Norwich to Tilbury

**Document: 9.1 Notification of proposed change to DCO application -
Change Request 1 (Bulphan)**

Application by National Grid Electricity Transmission (the Applicant) for an Order Granting Development Consent for the Norwich to Tilbury Project (Planning Inspectorate Reference EN020027)

Bulphan: Change to Third Party Access and Works (Change Request 1)

THE NATIONAL GRID (NORWICH TO TILBURY) ORDER
 PROPOSED CHANGE ORDER LIMIT PLANS - CHANGE REQUEST 1
 PROPOSED CHANGE TO THE PROJECT ORDER LIMITS
 REGULATION 5(2)(o)
 SECTION H (SHEET C, THURROCK COUNCIL)

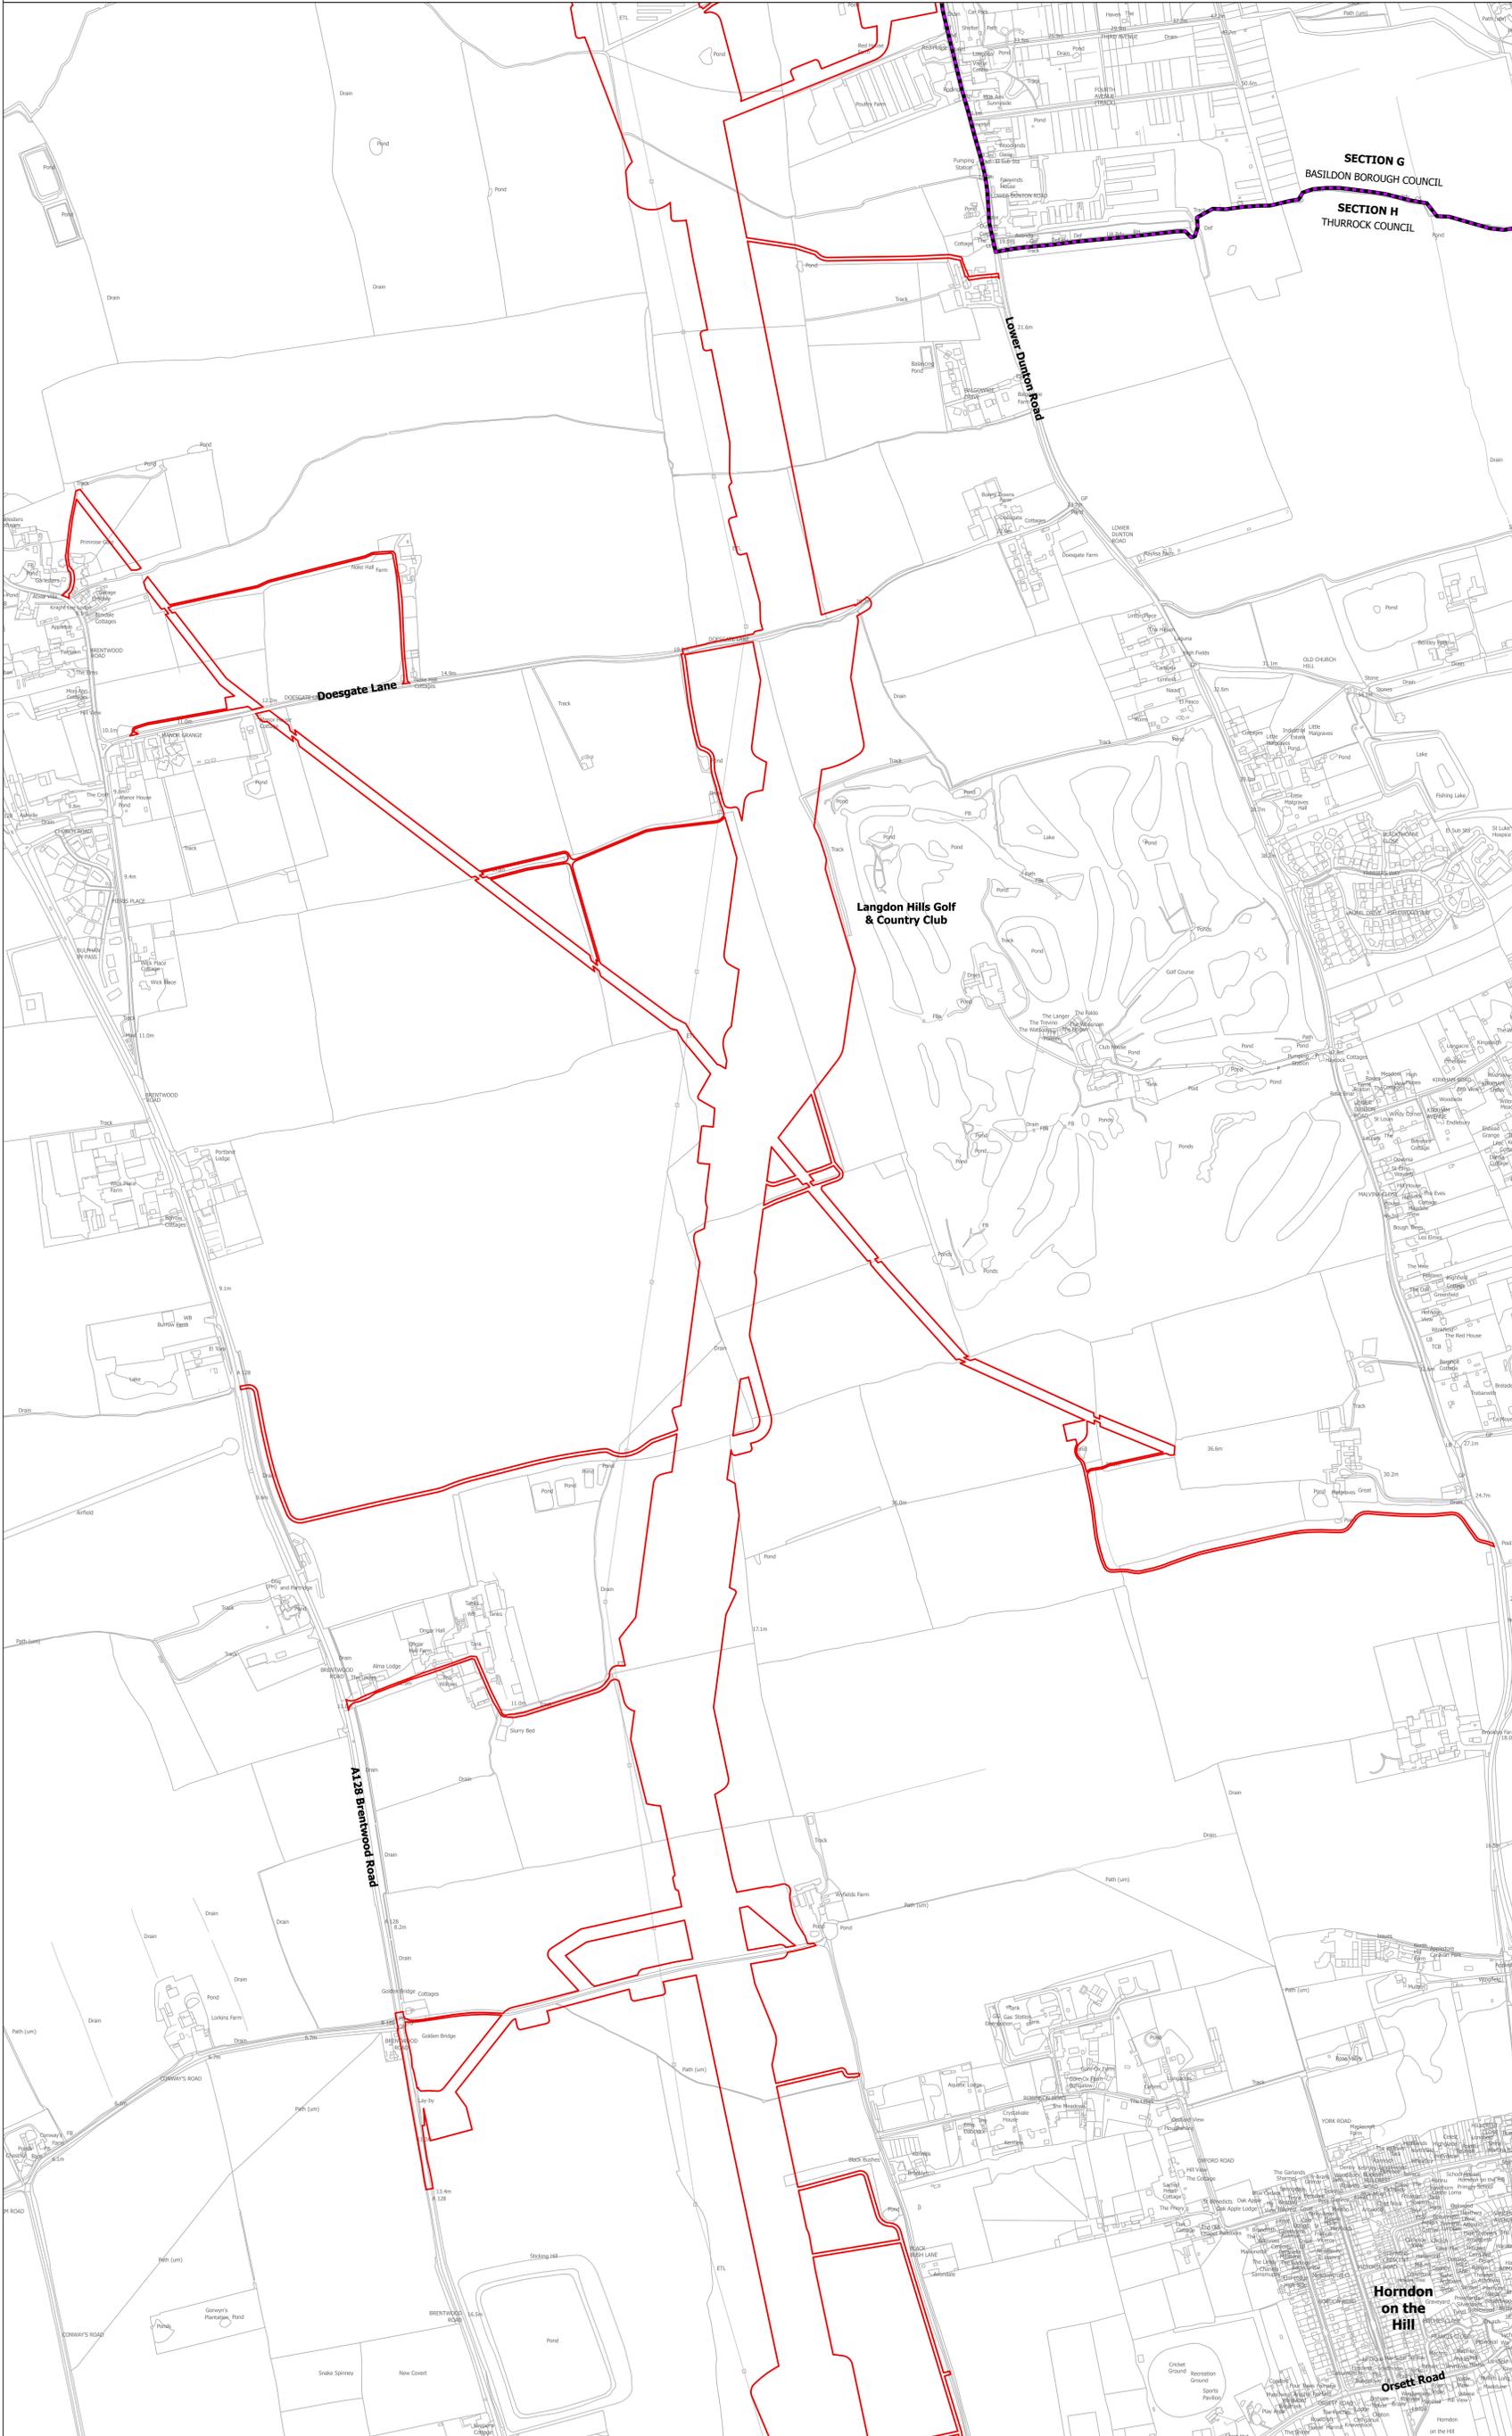
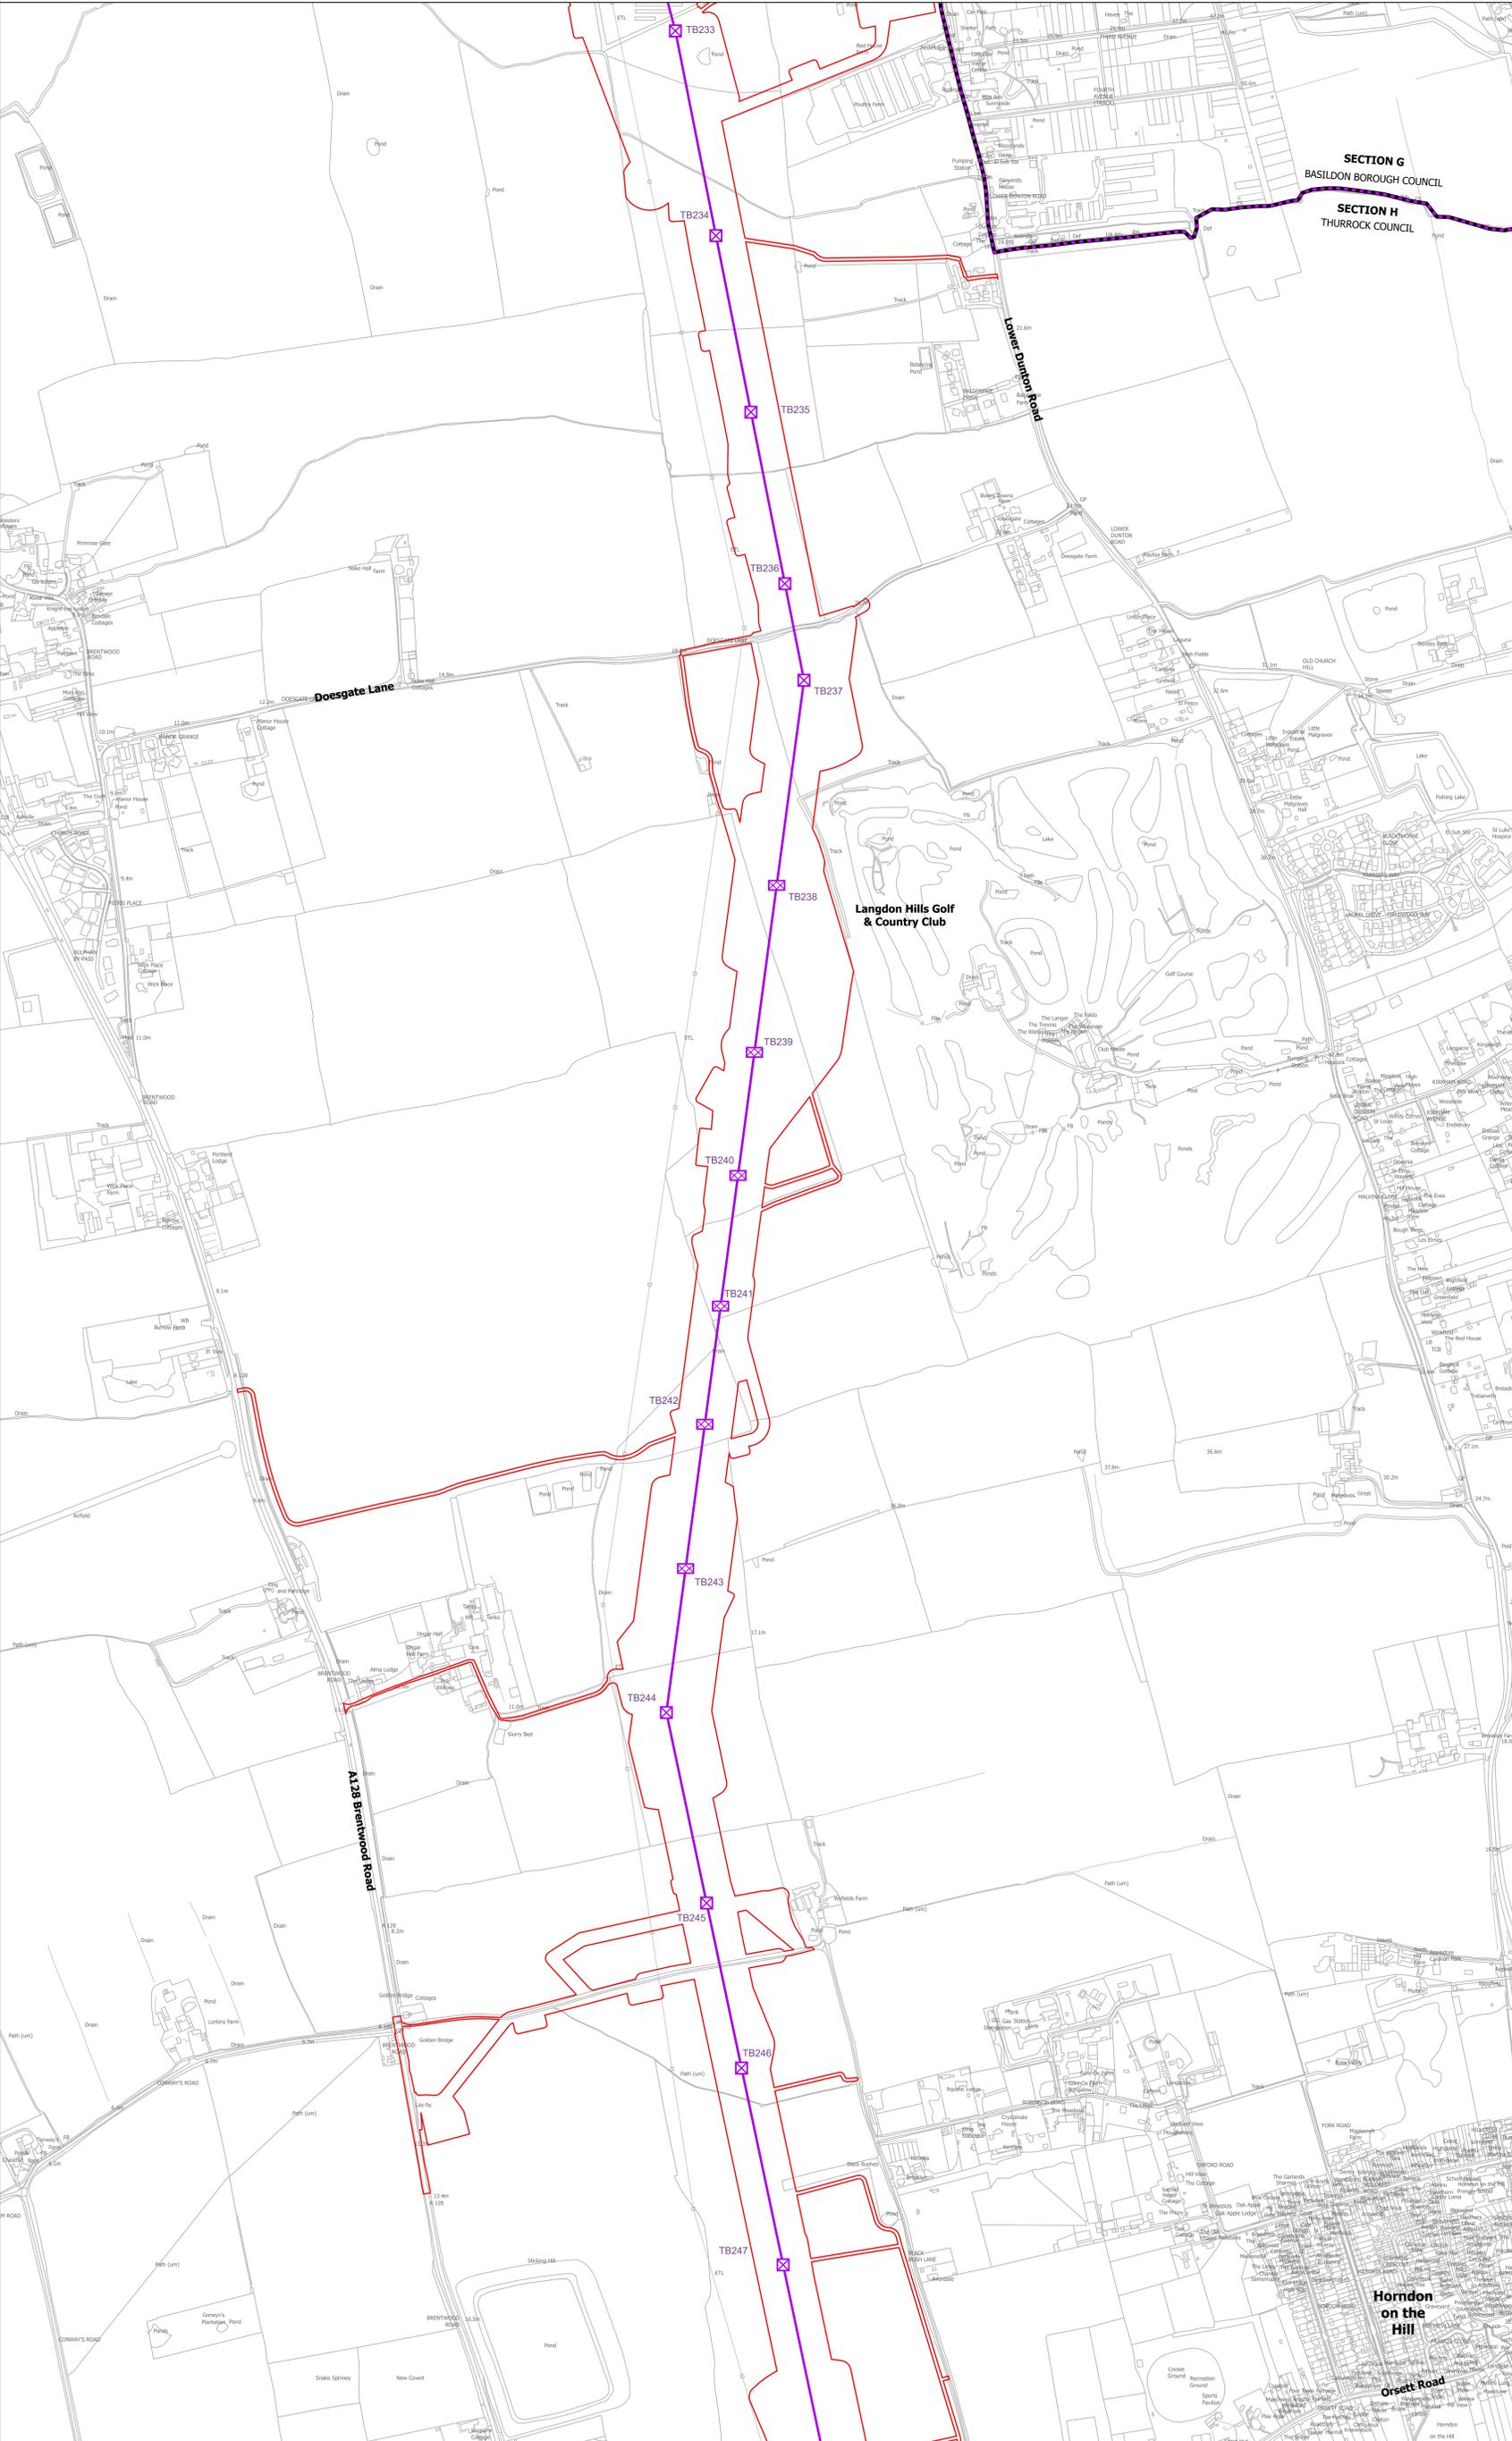
Change request number	Name of proposed change and description
1	Bulphan: Changes to third party access and works (Section H): an increase in the Order Limits to facilitate works required for the protection of the existing Thames to Buncefield Multifuel Pipeline, west of Langdon Hills Golf Club. This proposed change responds to feedback concerning accelerated corrosion on existing buried metallic services received from the British Pipeline Agency Ltd (BPA) who act as the agent for the owner, United Kingdom Oil Pipelines Limited (UKOP).

- 2.1.5 The proposed alignment for the Project (between Pylon TB239 and TB240) (see Section H of **Works Plans (APP-024)**) will cross the Thames to Buncefield Multifuel Pipeline to the west of Langdon Hills Golf Club. The pipeline, which forms part of the national fuel infrastructure network, is operated by the British Pipeline Agency Ltd (BPA) who act as agent for the owner United Kingdom Oil Pipelines Limited (UKOP).

- 2.1.6 As part of ongoing technical and survey work to inform detailed design, the Applicant has undertaken pipeline studies. The work identified the need for mitigation works to be carried out in respect of the existing Thames to Buncefield Multifuel Pipeline. The proposed measures are likely to involve the installation of zinc earthing strips parallel to, and along, an approximately 2.7km length of the existing pipeline, along with the installation of surface mounted monitoring equipment units. Temporary working and laydown areas will also be required.

- 2.1.10 The Order Limits are to be increased as a consequence of the proposed change, with powers of compulsory acquisition and temporary possession to be sought by the Applicant over the additional land intended to be brought within the Order limits. Accordingly, the CA Regulations are engaged.

2.1.12 The proposed change to the Order Limits is shown on the figures in **Appendix A**.
